London Luton Airport Expansion

8.11 Statement of Common Ground between London Luton Airport Limited and National Highways (Tracked Change Version)

**8.11 STATEMENT OF COMMON GROUND BETWEEN LONDON
LUTON AIRPORT LIMITED (TRADING AS LUTON RISING) AND
NATIONAL HIGHWAYS (TRACKED CHANGE VERSION)**

Deadline:	Deadline 11
Planning Inspectorate Scheme Reference:	TR020001
Document Reference:	TR020001/APP/8.11
Author:	Luton Rising

Figure 4 - An extract from the interventions's drawing M1J10-NB-A-01

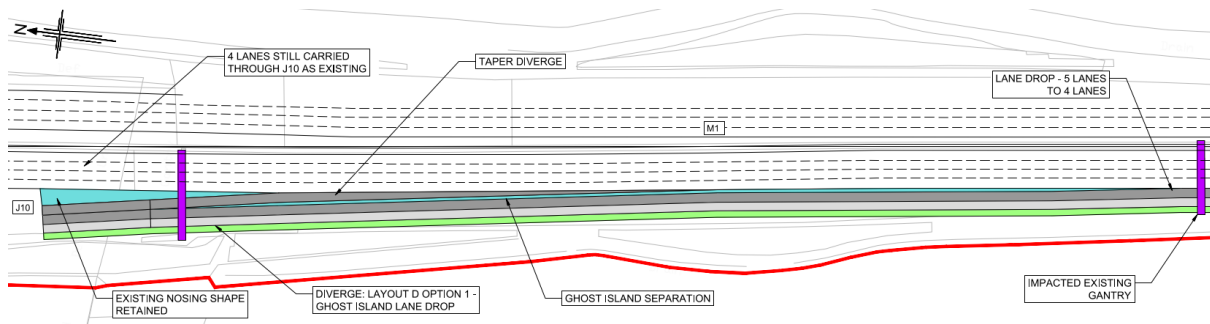
3.2	M1 Junction 10			
3.2.1	<p>M1 Junction 10 Design – <u>DCO Works</u></p>	<p>The design of the mitigation at M1 Junction 10 to enable the SRN to operate safely and effectively is acceptable, as far as it goes. However, some</p>	<p><u>The design of the mitigation at M1 Junction 10 has been reviewed alongside National Highways, including the completion of a Stage 1 Road</u></p>	<p>Ongoing<u>Agreed with regards to Junction 10 Design but not the impact on</u></p>

SoCG ID	Matter	National Highways position	The Applicant position	Agreed / Ongoing / Not agreed
			work.	
3.2.2	<u>M1 Junction 10 – South facing slips</u>	<p><u>National Highways have identified further remedial measures as we remain concerned about the operation of the south facing slip roads and their interaction with the mainline carriageway based on the VISSIM modelling results (REP9-072). The identified concerns arise in the future baseline but there are outstanding concerns about the robustness of the modelling and National Highways believe there is a risk that safety performance will worsen with future airport growth.</u></p> <p><u>and Notwithstanding this, National Highways’ position is that no development should be permitted unless and until an agreed mitigation scheme is developed. -National Highways would therefore requires a Grampian requirement condition to address their concerns. National Highways position is that the Applicant should fully</u></p>	<p><u>The transport modelling included within the application for development consent clearly sets out how the Applicant has addressed the impacts of the Proposed Development on the highway network including the SRN. The Rule 9 modelling has considered specifically the impacts on the south facing slips.</u></p> <p><u>The Applicant therefore disagrees that a Grampian condition is required.</u></p> <p><u>The Applicant notes that the concerns that have been set out by National Highways regarding the south facing slips relate to forecast demand even in the absence of the Proposed Development. Whilst the Applicant acknowledges that the Proposed Development would form part of any future forecast demand, the issues identified by National Highways</u></p>	<p><u>Not agreed</u> <u>Position not confirmed by National Highways</u></p>
